Rezoning Transportation Analysis

Petition Number: 2021-154

Revision Log:

Date	Description
12-28-2021	First Review (KP)
01-27-2022	Second Review (KP)

TECHNICAL DATA /  
SCHEMATIC SITE

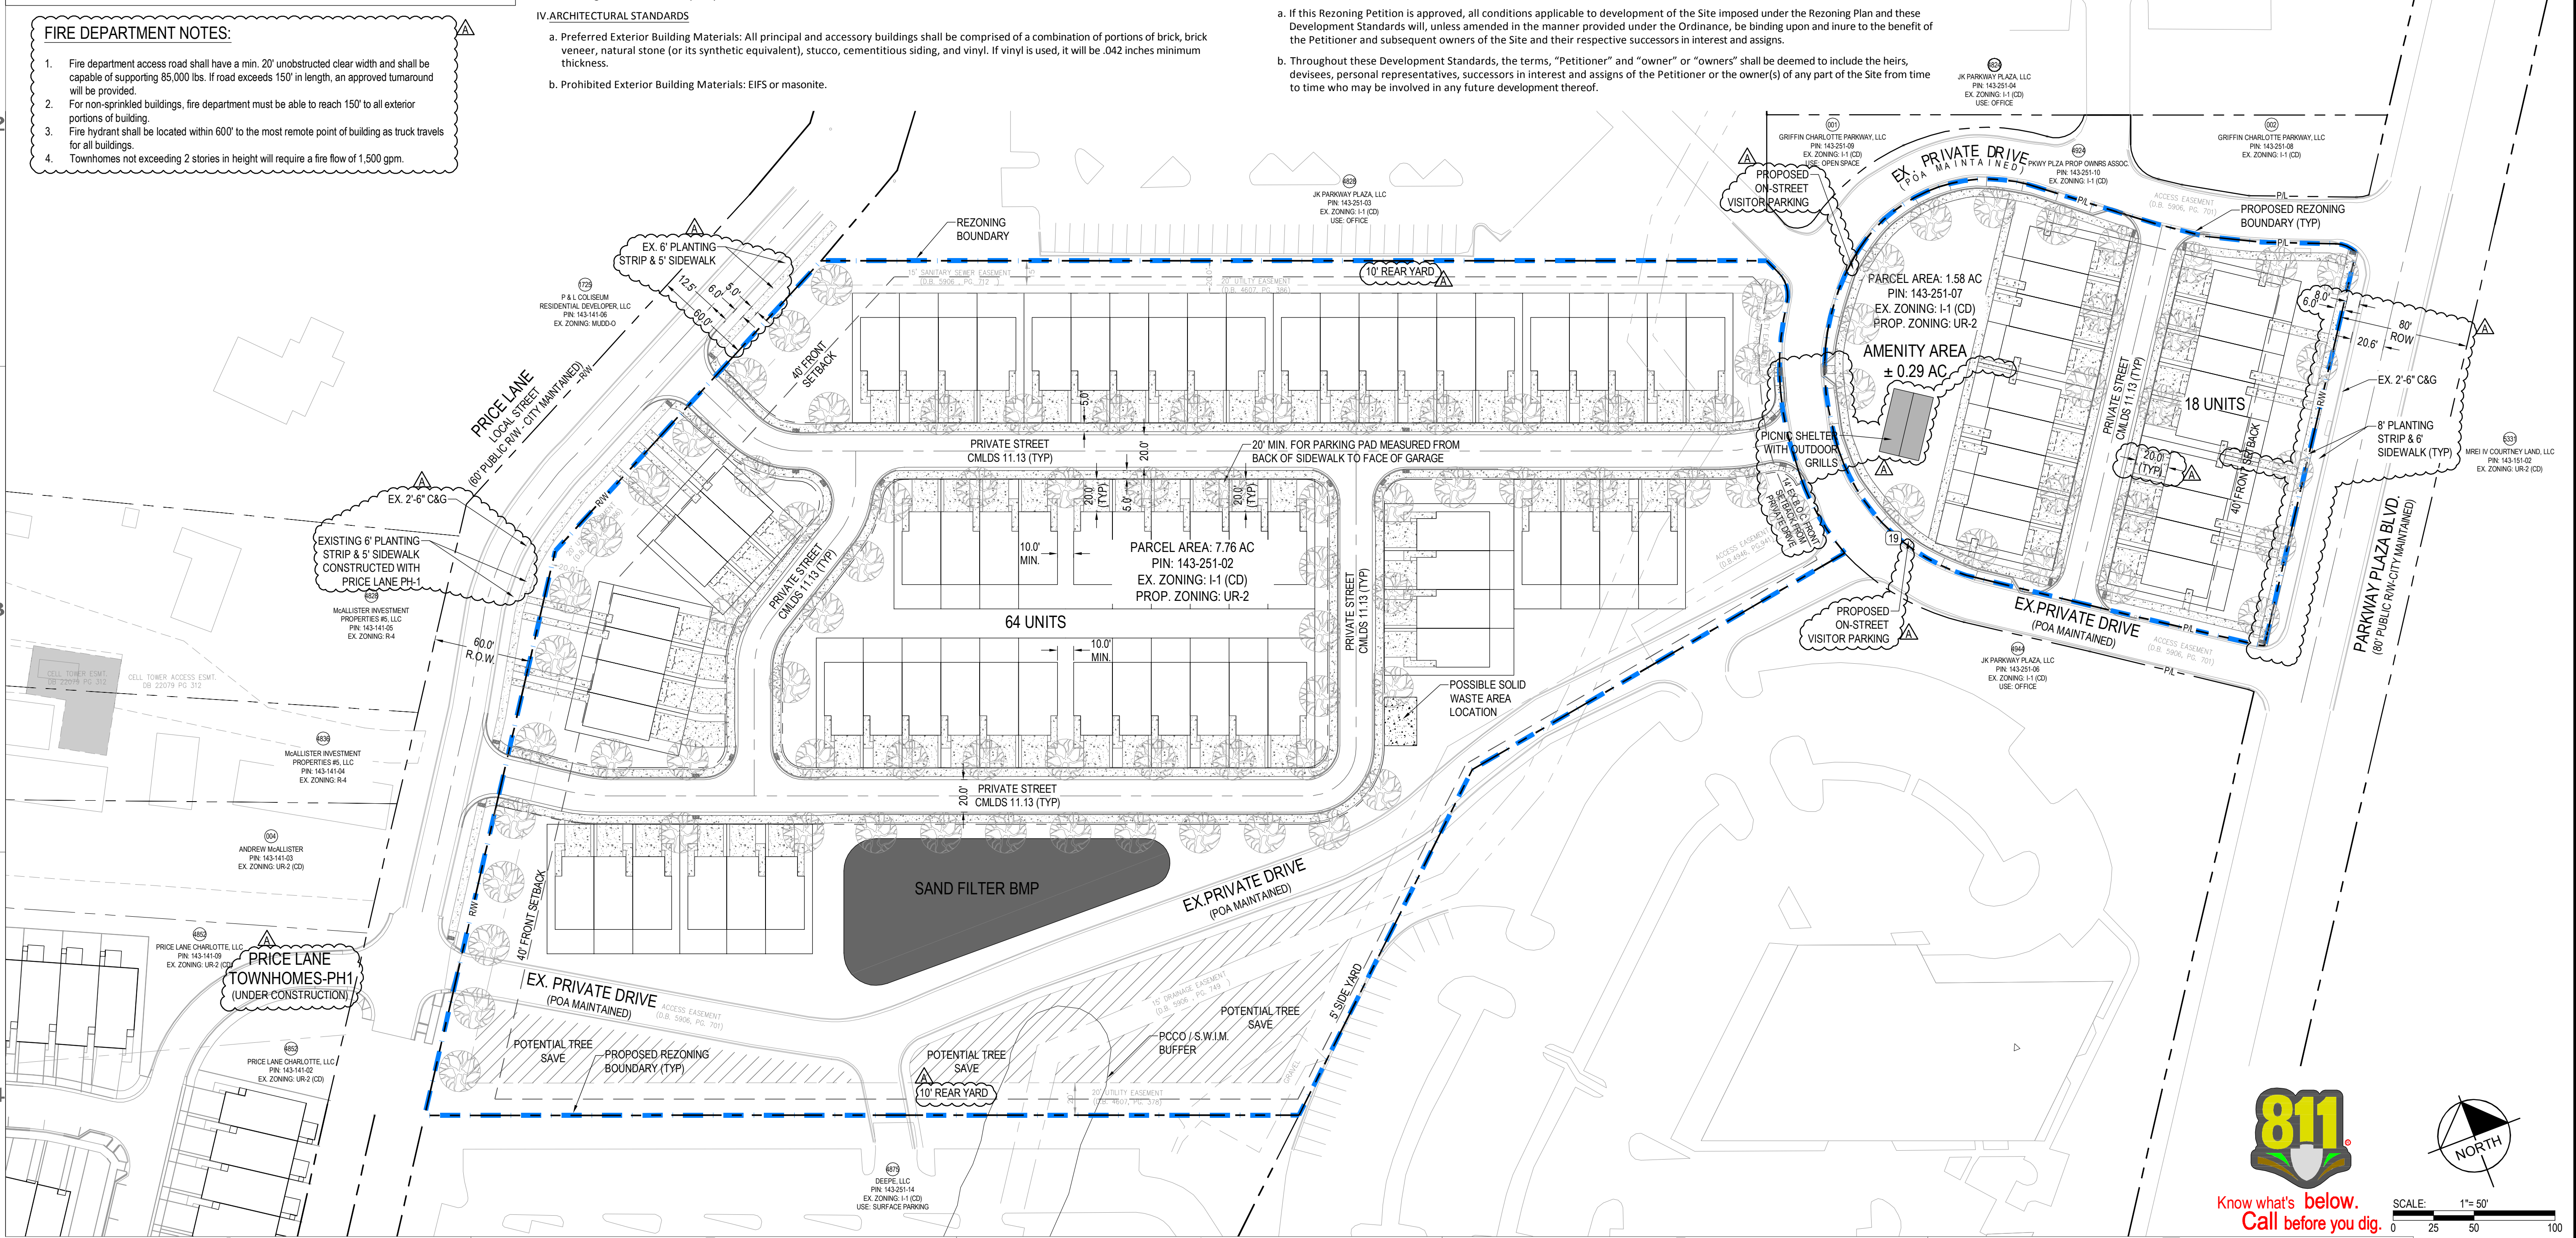
7. Revise the site plan by modifying the proposed internal private street network by removing the proposed southern driveway, on Price Lane, and providing an internal connection to the existing private street.

Update to Comment from 01-17-2022 Site Plan: Revise the site plan and conditional note III.b by removing the proposed southern driveway on Price Lane.
